Reference: Stormwater impact from proposed Sydney International Convention, Exhibition and Entertainment Precinct - Case Numbers 131522, 131523 and 131525

The following is Sydney Water's response to the Flooding and Stormwater report, prepared by Hyder Consulting Pty Ltd, for each of the three precincts. This information may change or further refined during the design process for this development.

100 YEAR ARI PROPOSED DEVELOPMENT  
FLOOD DEPTH AND LEVEL CONTOURS  
WITHOUT CULVERT AMPLIFICATION

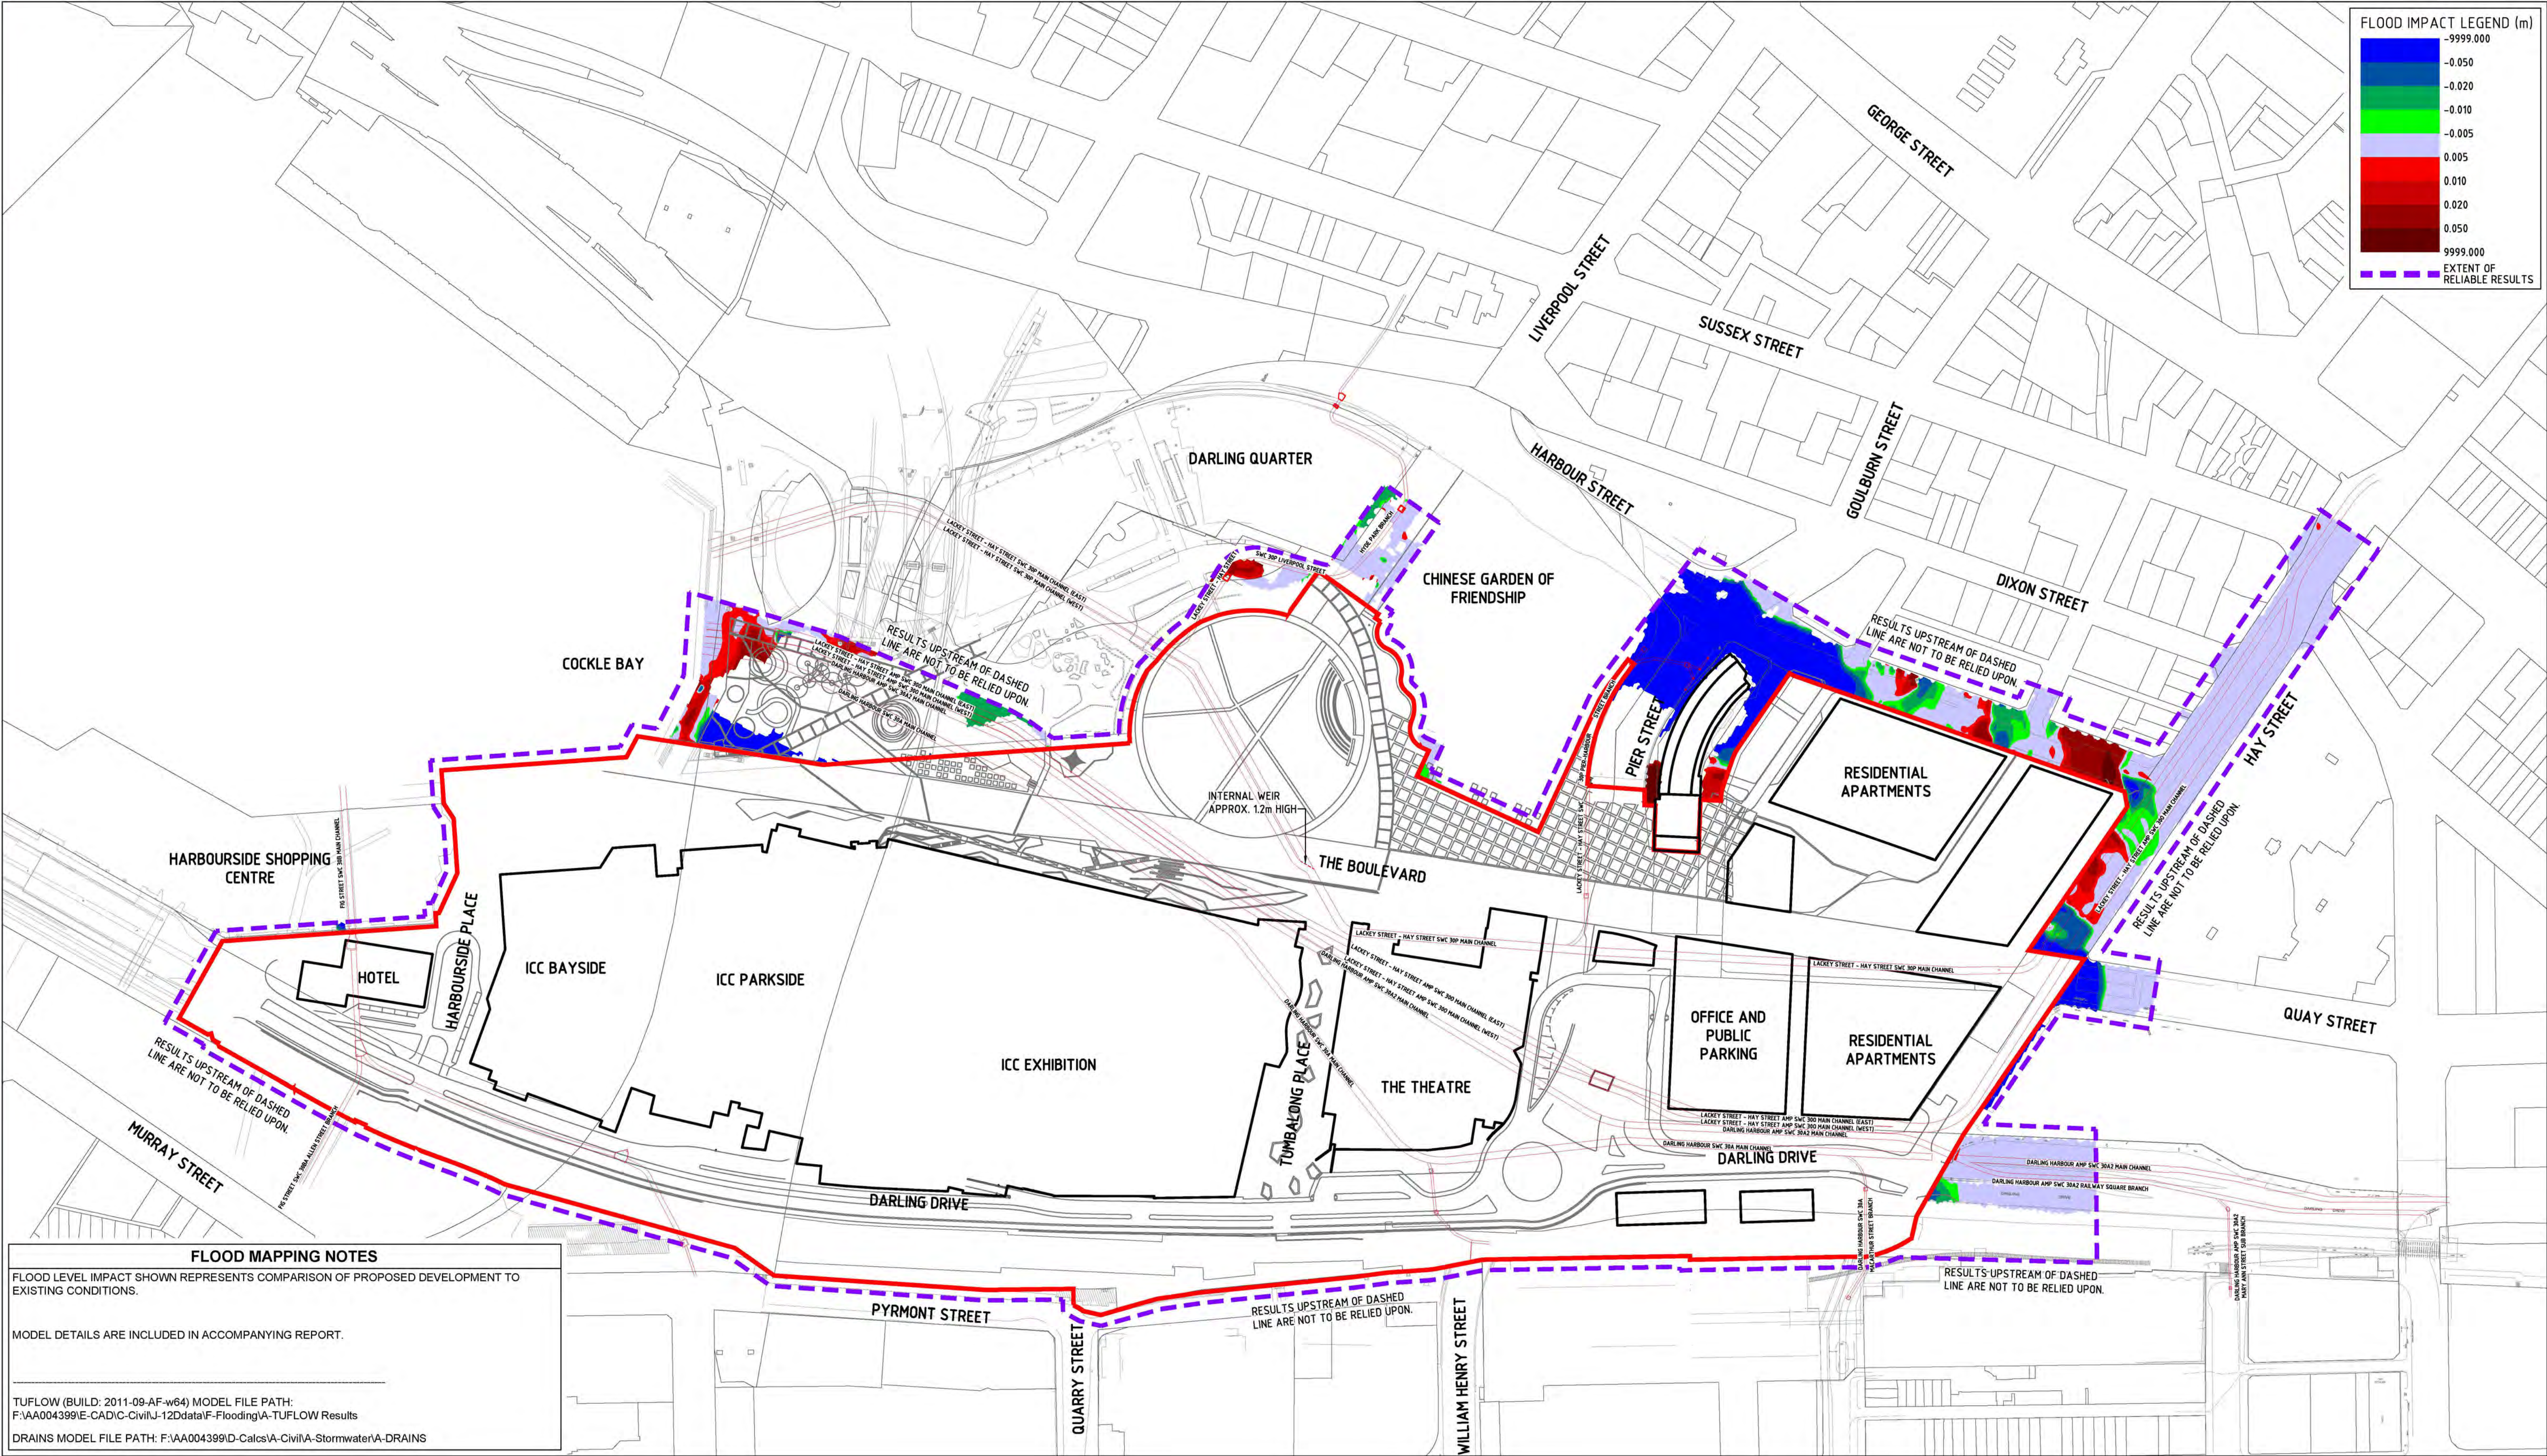
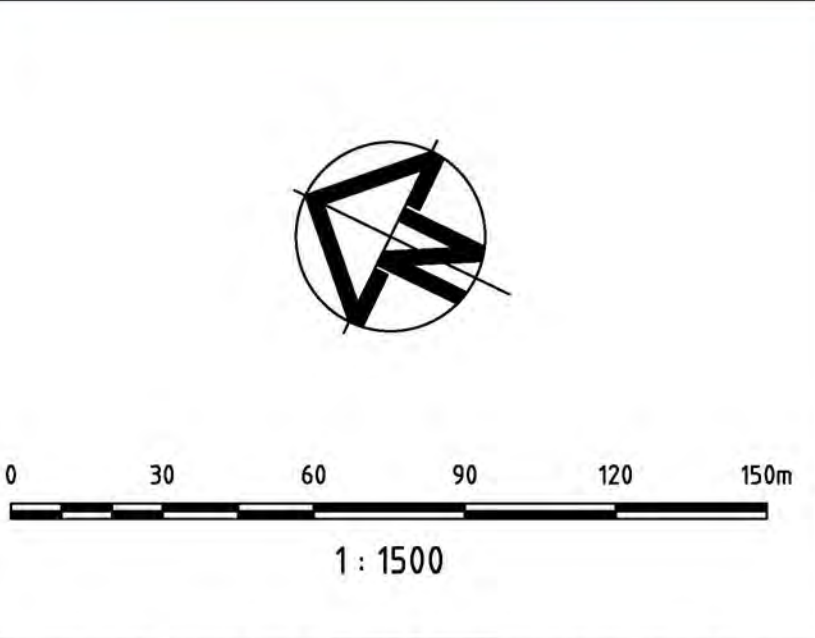
Stormwater and Flooding report indicates that the proposed provisional hydraulic hazards are high. However it concludes that the impact of the proposed development with the culvert amplification would result in negligible flood impact. To support this statement the flood mitigation measures and associated risks identified need to be addressed including confirming design levels to undertake further modelling and developing a Floodplain Risk Management Plan.
